CITY OF ALBUQUERQUE

October 13, 2023

Re: SureStay Hotel Conversion
10330 Hotel Ave. NE
Traffic Circulation Layout
Architect's Stamp 09-29-23 (K21-D016F)

AS-101

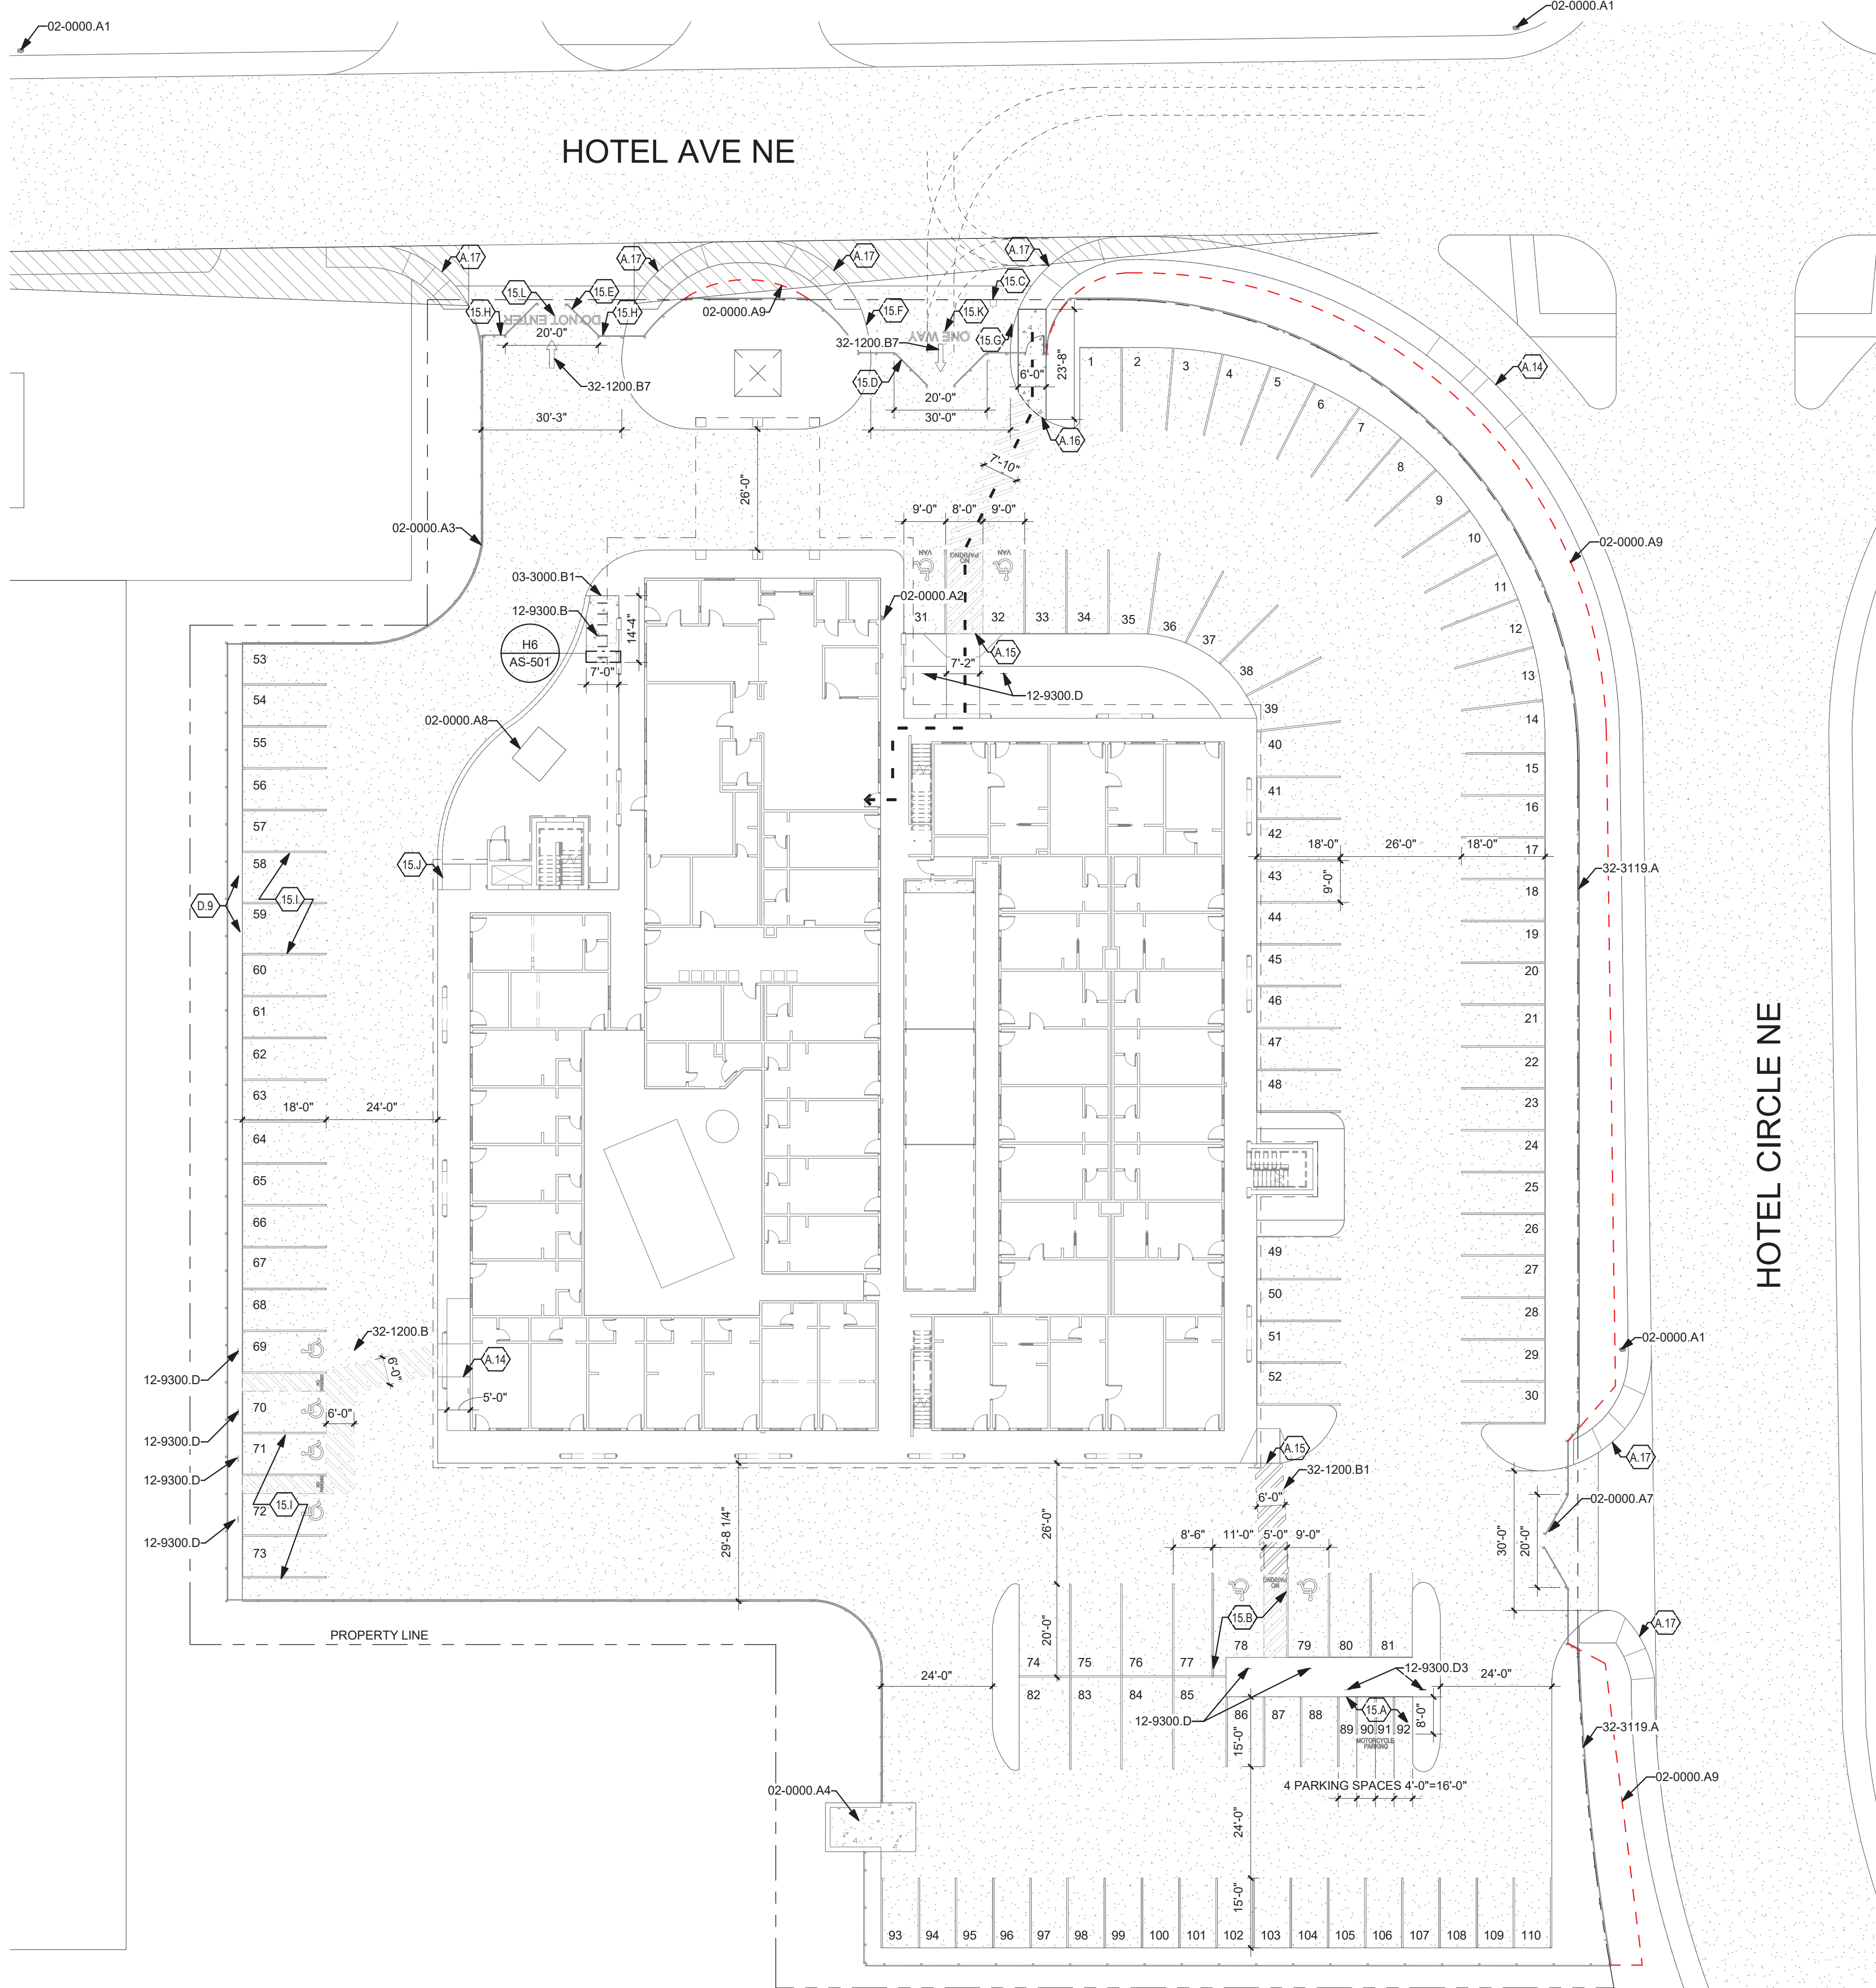
1. Please show a vicinity map showing the location of the development in relation to streets and well-known landmarks.
2. List the number of Bicycle parking spaces required by the IDO.

3. Keynote 02-0000A3: It appears the existing fence located within the public right of way. Any private structures that are located within public right-of-way such as fences and walls shall either be removed or else a revocable permit with the City is required in which an annual fee is paid per year, based on square footage of the encroachment.

4. Site Accesses:
 - All site accesses curb ramps must be updated to current standards and have truncated domes installed.
 - Please show on the site plan the necessary turnarounds in front of the gates. Because if a vehicle pulls up to the gate and is unable to enter, there should be sufficient space needs for the vehicle to turn around without backing into the roadway.

- All one-way drives shall have "One Way" and "Do Not Enter" signage and pavement markings. Please show detail and location of posted signs and striping.

5. Please list the width and length for all existing and proposed parking spaces. Some dimensions are not shown.
6. The ADA accessible spaces must include an access aisle. Van accessible aisles should be 8ft wide; all others should be 5ft wide.

7. The ADA accessible parking sign must have the required language per 66-7-352.4C NMSA 1978 **"Violators Are Subject to a Fine and/or Towing."** Please call out detail and location of signs.

8. The ADA access aisles shall have the words **"NO PARKING"** in capital letters, each of which shall be at least one foot high and at least two inches wide, placed at the rear of the parking space so as to be close to where an adjacent vehicle's rear tire would be placed. (66-1-4.1. B NMSA 1978)
9. ADA curb ramp at the corner of Hotel Ave. and Hotel Circle must be updated to current standards and have truncated domes installed.
10. Please show on the site plan these drive aisles width.

11. Motorcycle parking spaces shall be designated by its own conspicuously posted upright sign, either free-standing or wall mounted per the zoning code.

12. The pavement marking "MC" should be shown in the opposite direction for motorcycles entering the parking space.
13. All bicycle racks shall be designed according to the following guidelines:

17. Per the IDO, a 6 ft. wide ADA accessible pedestrian pathway is required from the public sidewalk to the building entrances. Please clearly show this pathway and provide details.

18. Per DPM, a 6 ft. wide ADA accessible pedestrian pathway is required from the ADA parking stall access aisles to the building entrances. Please clearly show this pathway and provide details.

19. Please clarify the ADA pathways by clearly labeling flush surface or ramps and show the doorways on the site plan. Please ensure that all interior ADA curb ramps are updated to current standards.

20. Show the clear sight triangle and add the following note to the plan: "Landscaping and signage will not interfere with clear sight requirements. Therefore, signs, walls, trees, and shrubbery between 3 and 8 feet tall (as measured from the gutter pan) will not be acceptable in the clear sight triangle.

21. Please specify the City Standard Drawing Number when applicable.
22. Add a note stating "All broken or cracked sidewalk must be replaced with sidewalk and curb & gutter." A build note must be provided referring to the appropriate City Standard drawing.

H6 BIKE RACK DETAIL

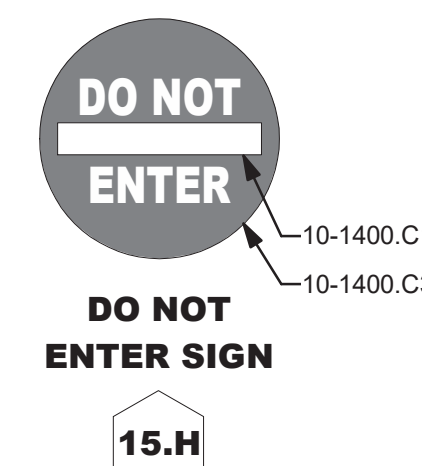
- a. The rack shall be a minimum 30 inches tall and 18 inches wide.
 - b. The bicycle frame shall be supported horizontally at two or more places. Comb/toaster racks are not allowed.

- c. The rack shall be designed to support the bicycle in an upright position. See the IDO for additional information.
 - d. The rack allows varying bicycle frame sizes and styles to be attached.

- e. The user is not required to lift the bicycle onto the bicycle rack.
 - f. Each bicycle parking space is accessible without moving another bicycle.

14. Bicycle racks shall be sturdy and anchored to a concrete pad.
15. A 1-foot clear zone around the bicycle parking stall shall be provided.
16. Bicycle parking spaces shall be at least 6 feet long and 2 feet wide.
